REPORT REF: 217940-R07

This report is intended to verify that the Sustainable Drainage Systems (SuDS) which form part of the proposed development at Land at Ford Road, Arundel have been installed in accordance with the detailed design drawings. Conclusions have been drawn based on evidence provided by Esquire Developments including delivery notes, photographs and an as-built survey which has been compared against ACE's construction drawings.

LAND AT FORD ROAD, ARUNDEL

SuDS VERIFICATION REPORT

HEADWALL SECTIONS - SHEET 1

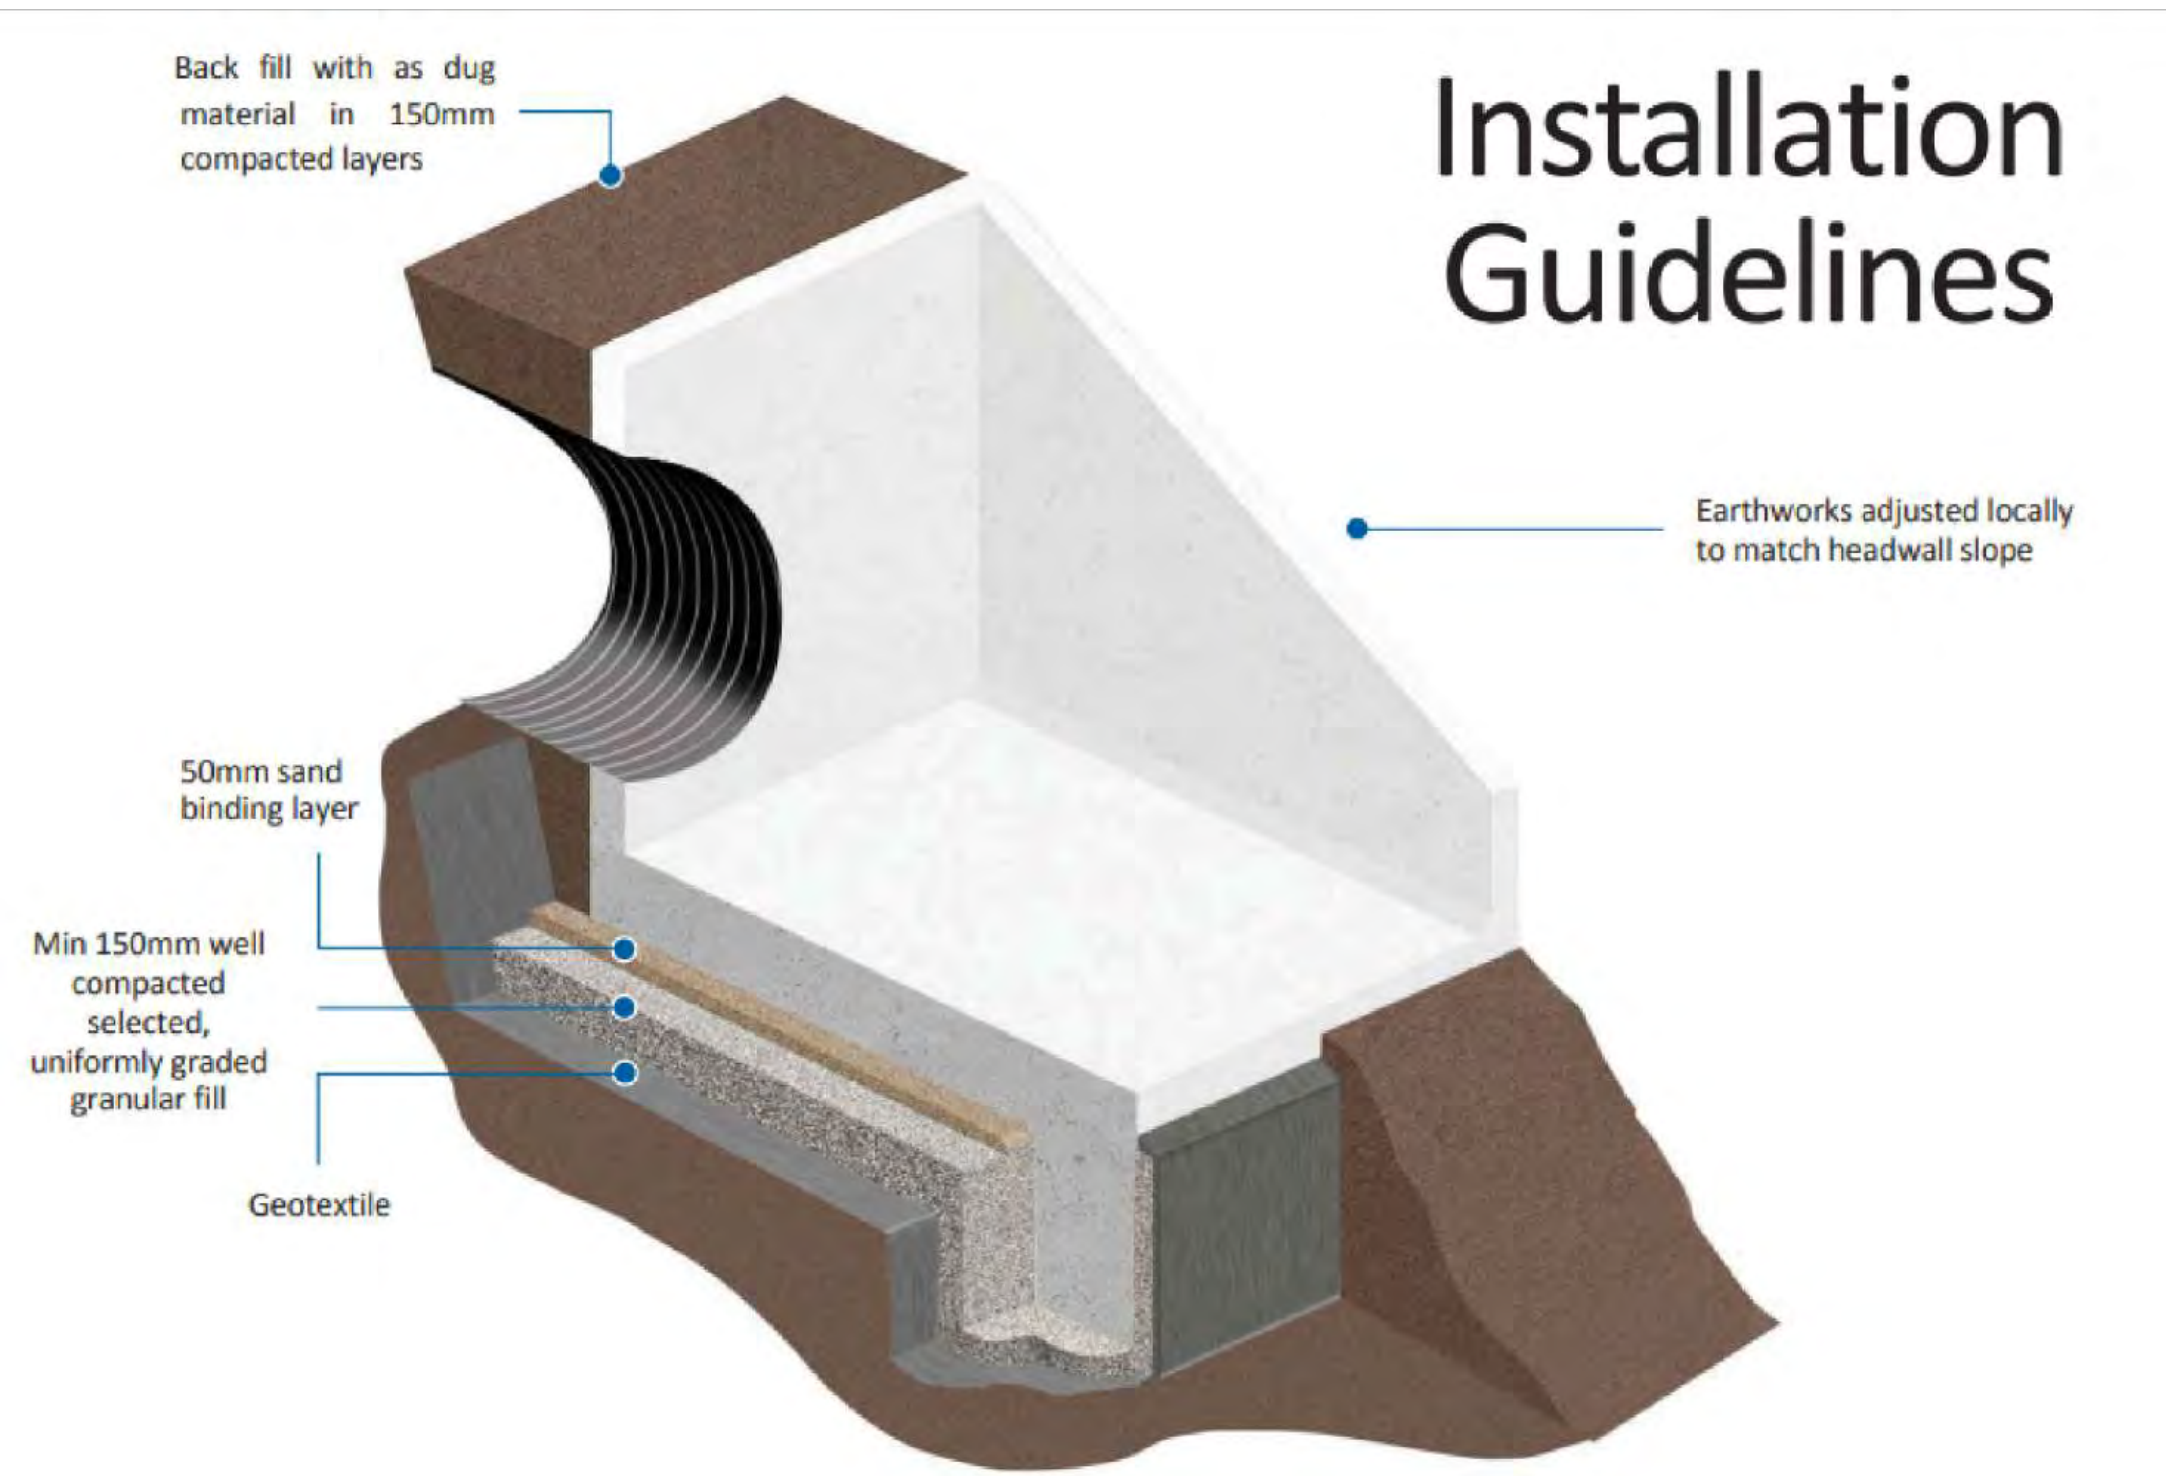
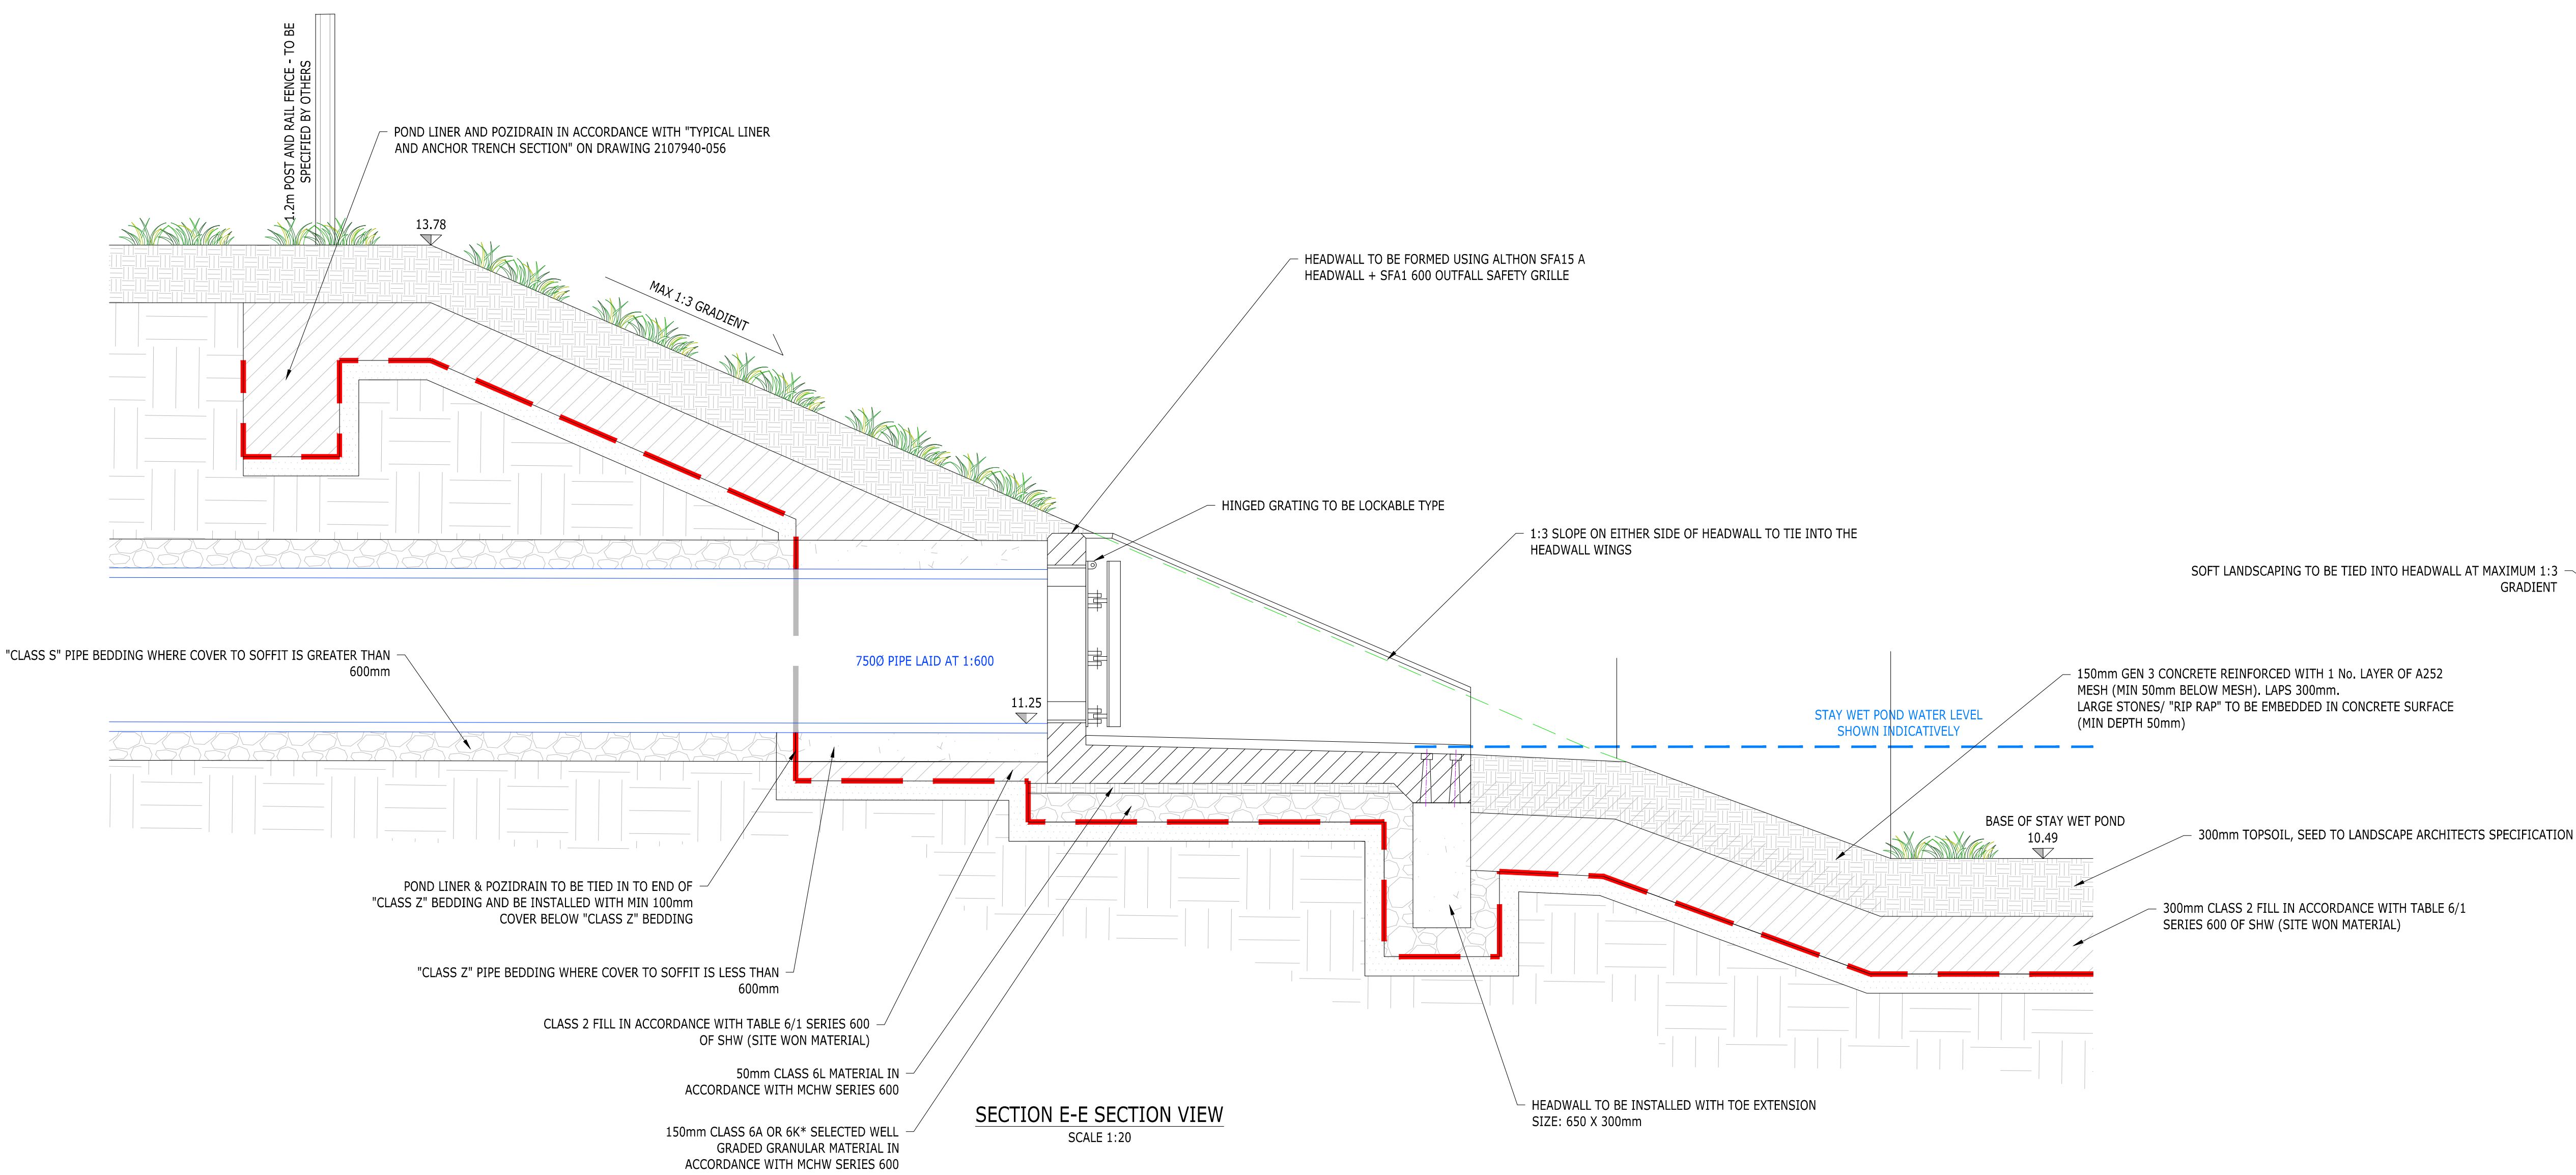
Finally it is noted that the headwalls on the pond were originally designed as concrete bagwork headwalls; these have been installed as ragstone headwalls which the designer confirms are an acceptable alternative.
